Recommendation Report for Planning Permission for Works or Extension to a Dwelling

REF NO: Y/13/26/HH

LOCATION: Longacre
Maypole Lane
Yapton
BN18 0DR

PROPOSAL: Proposed oak framed carport to northern end of existing dwelling.

PROPOSED LOCATION & BLOCK
PLANS

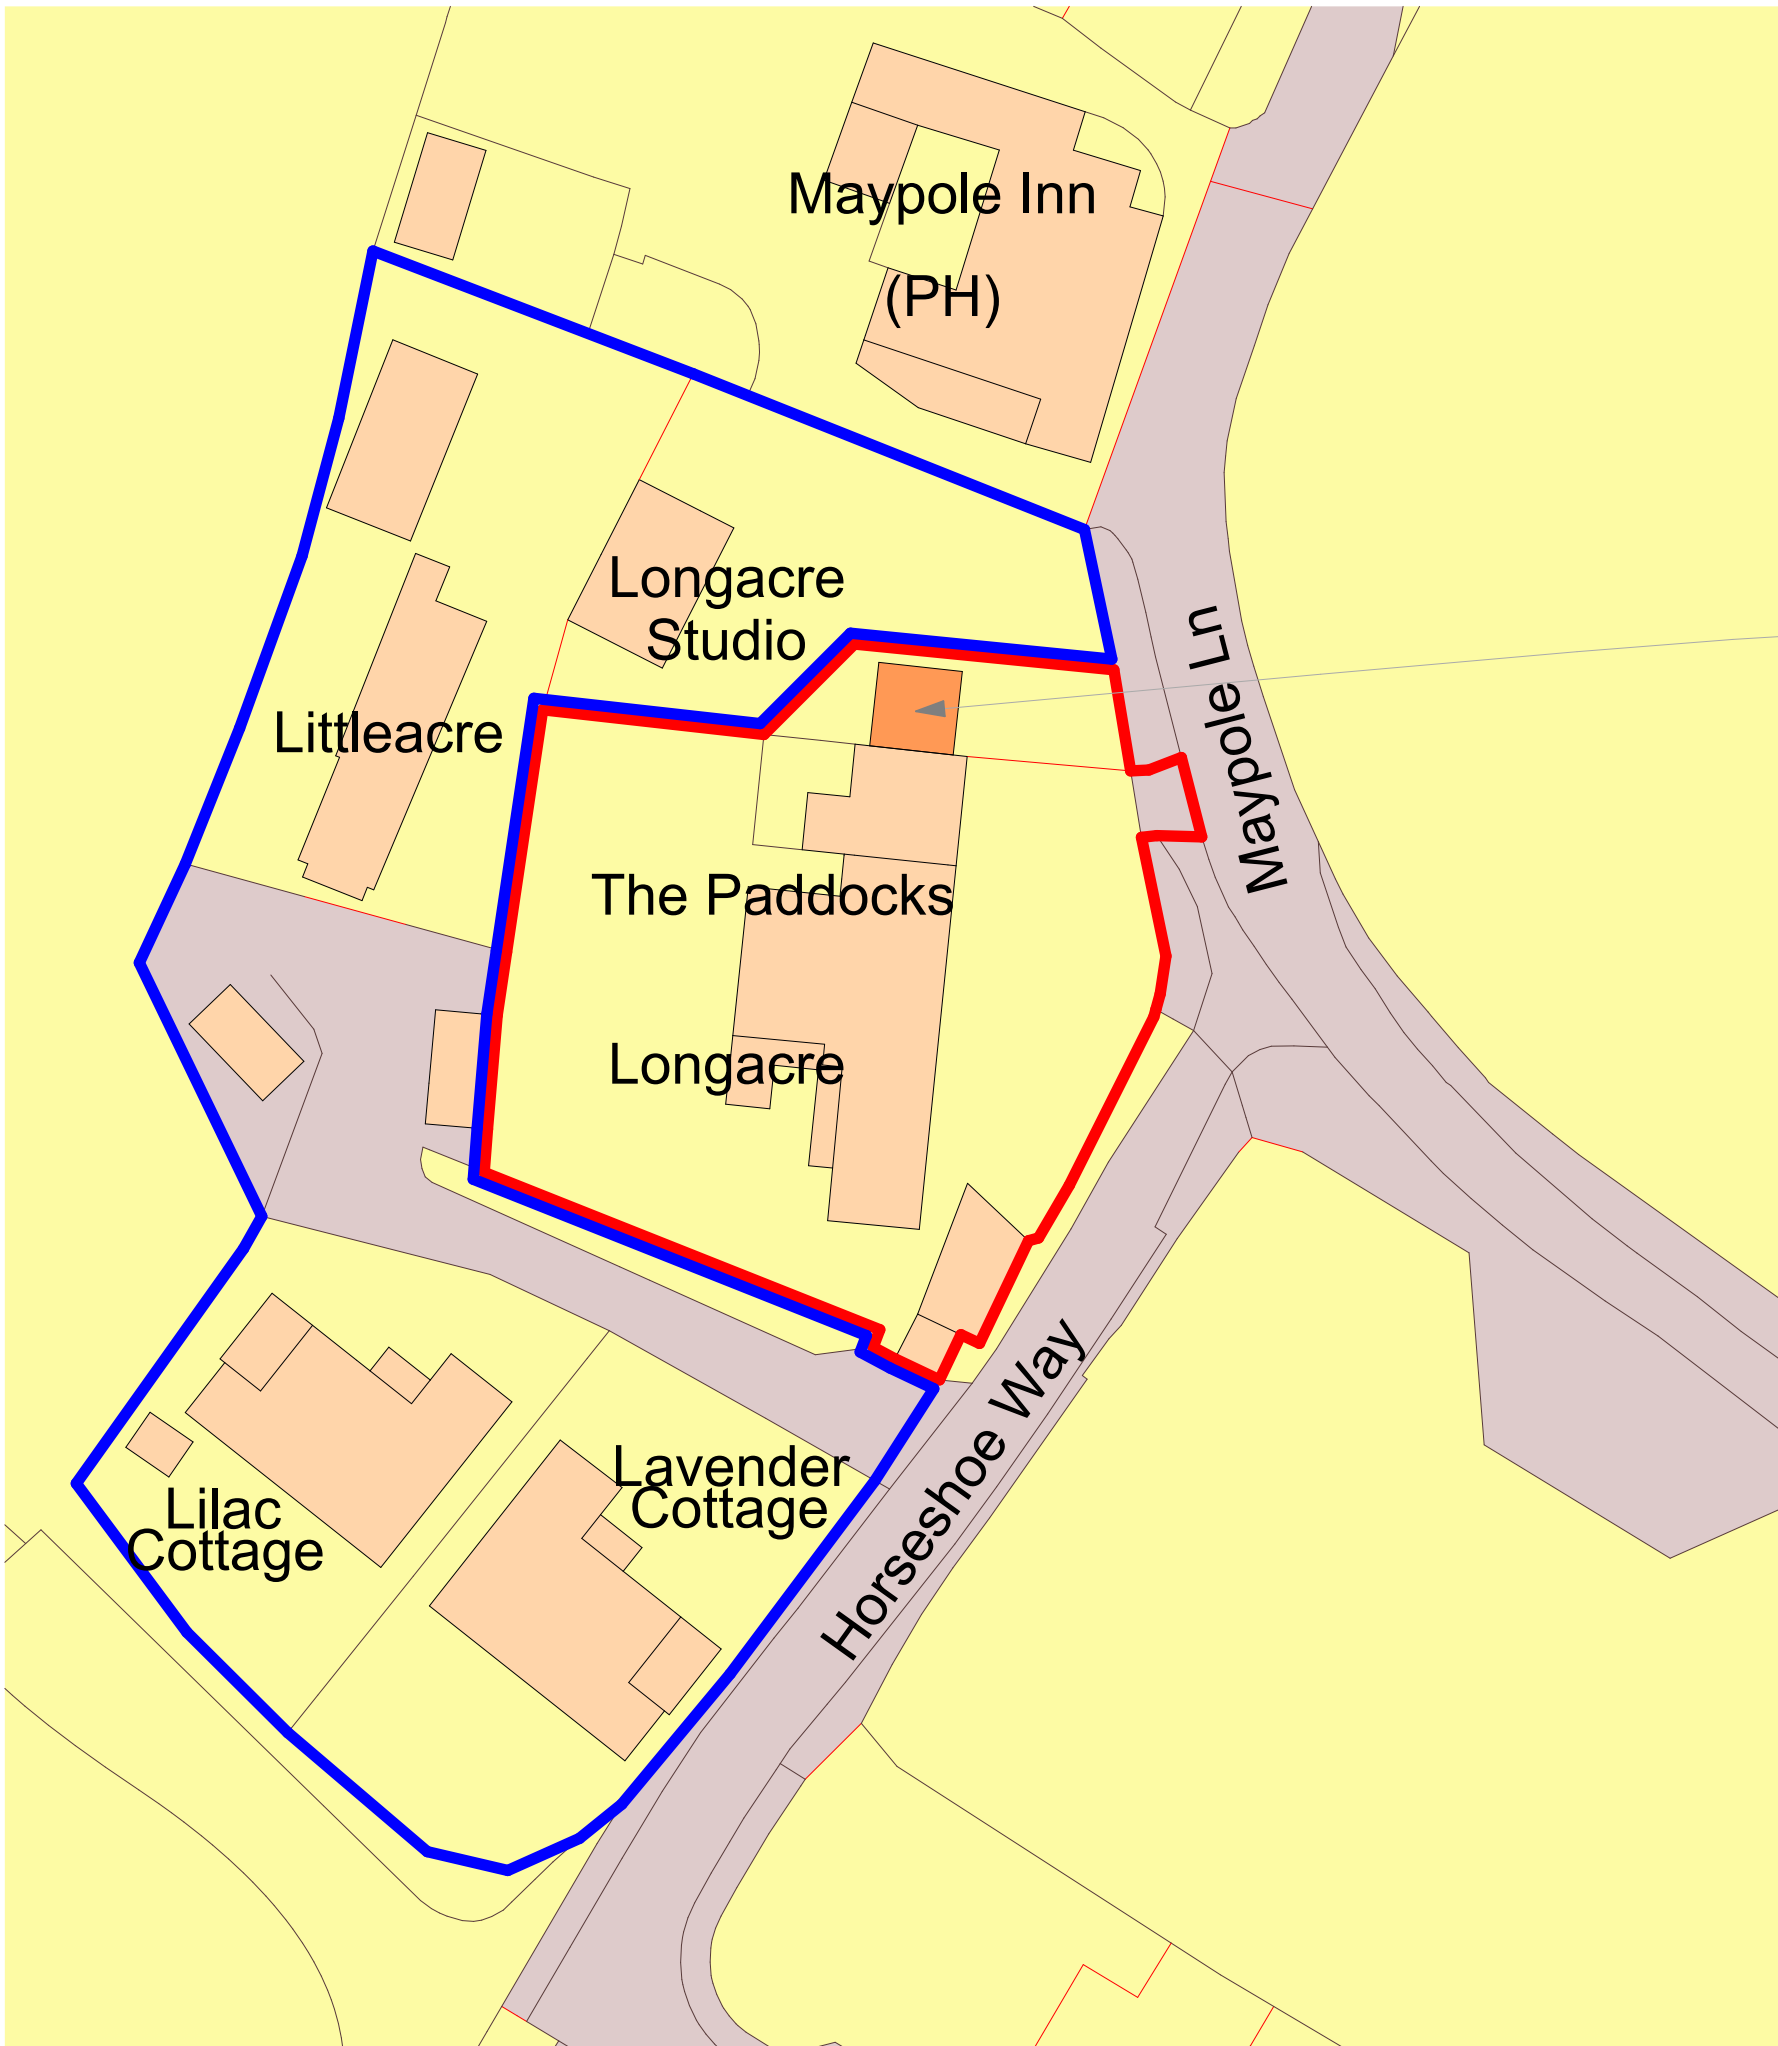
The proposed car port would be located to the north of the host dwelling and set back 11m from the highway. The nearest neighbouring property is situated to the north at a distance of approximately 17m, separated from the application site by an access road and existing hedgerow. Given the spacing maintained between the car port and the neighbour to the north, the proposal would not result in any overbearing or overshadowing impacts to this neighbouring property.

PROPOSED PLAN AND ELEVATIONS

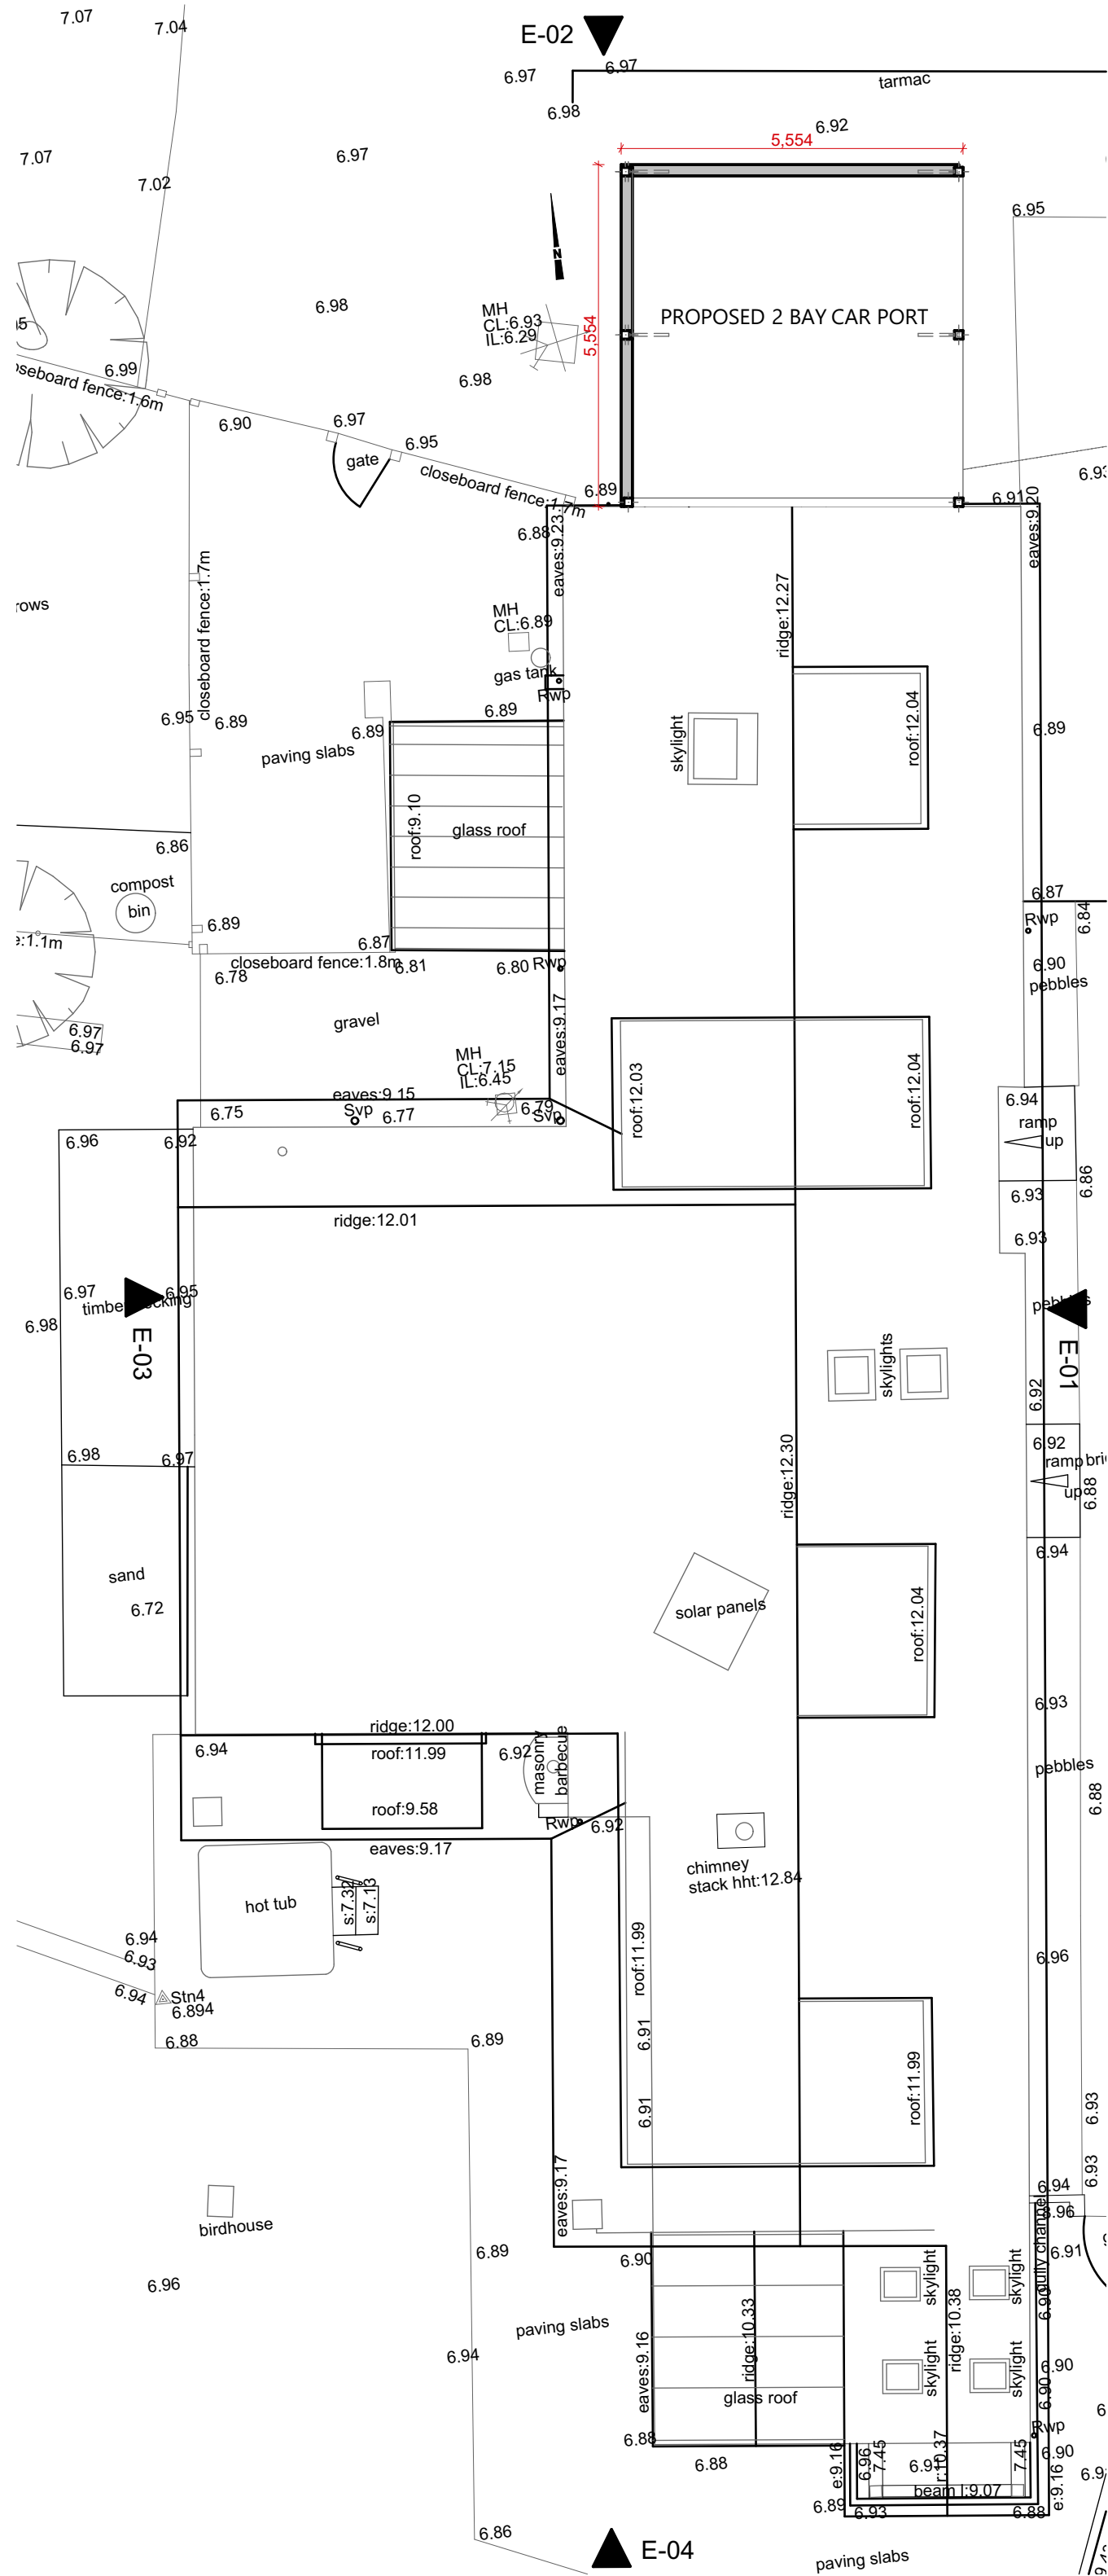
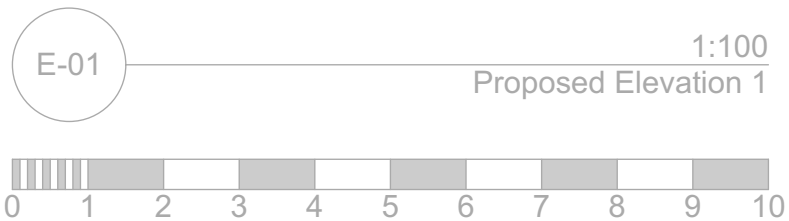
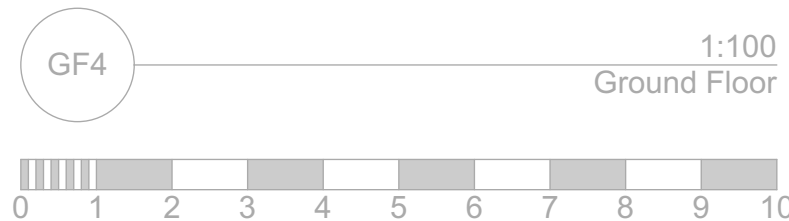
The proposed car port would measure approximately 5.5m in depth and 5.5m in width and would be adjacent to the northern side boundary. The structure would have a maximum ridge height of approximately 5m and an eaves height of approximately 2.7m. It would incorporate a pitched roof finished with red/brown roof tiles to match the host dwelling, together with low-level facing brickwork and timber shiplap cladding with oak-framed knee braces.

It is noted that some of the proposed external materials would not directly match the existing dwelling, which is finished in white render, and this would be contrary to Section M of the Arun Design Guide (ADG). However, timber cladding is present elsewhere within the site and the use of such materials is characteristic of this type of ancillary development. In addition, planning permission reference Y/60/22/PL approved timber cladding to the host dwelling, which, if implemented, would result in the proposed car port materials matching the dwelling and the proposed materials would therefore be acceptable. The structure would also be set back approximately 1.2m from the principal elevation and would reflect the roof pitch of the existing dwelling, thereby responding to the existing building design in accordance with the ADG.

Due to its siting, the car port would be visible within the street scene. Nevertheless, given its appropriate scale, and the existing site context, including the presence of a three-door garage already visible from the public realm, the proposal would not appear unduly prominent or visually intrusive. The development would also benefit from partial screening by existing hedgerow. As such, the proposal would not adversely affect the character or appearance of the surrounding area in accordance with Policy D DM1 of the Arun Local Plan (ALP).

The eastern elevation of the car port would remain open to facilitate vehicular access and would overlook the front amenity space of the host dwelling only. The proposal would not result in overlooking of neighbouring properties and would therefore not result in any loss of privacy. Overall, the proposal would not cause harm to neighbouring residential amenity in terms of overbearing, overshadowing, or overlooking. The development is therefore in accordance with ALP policy D DM1 and the ADG.

The application site is located within Parking Zone 1. In accordance with the Arun Parking Standards (APS), a four-bedroom dwelling is required to provide three parking spaces. It is noted that the proposed car port bays would not meet the best practice minimum internal dimensions for garages or car ports. The ADG states that parking spaces should measure at least 6m by 3m internally in order to qualify as a parking space. As such, the proposed car port cannot be counted towards the formal parking provision.

The proposed car port would be constructed over an existing area of hardstanding (tarmac) and would not include any drainage infrastructure. It is also noted that, under permitted development, a single-storey side extension with a larger footprint could potentially be erected, which remains a material consideration notwithstanding that permitted development rights have been removed at the site. As such, the proposed development would not result in an increase in impermeable surfacing and would not materially increase the risk of surface water flooding within the site or the surrounding area.

It is noted that the Council's Drainage Engineers have raised an objection to the proposal. However, given that there would be no increase in impermeable area and for the reasons outlined above, the development would not increase the chances of flooding elsewhere in the district. The proposal is therefore in accordance with Arun Local Plan policies W DM1 and W DM3.
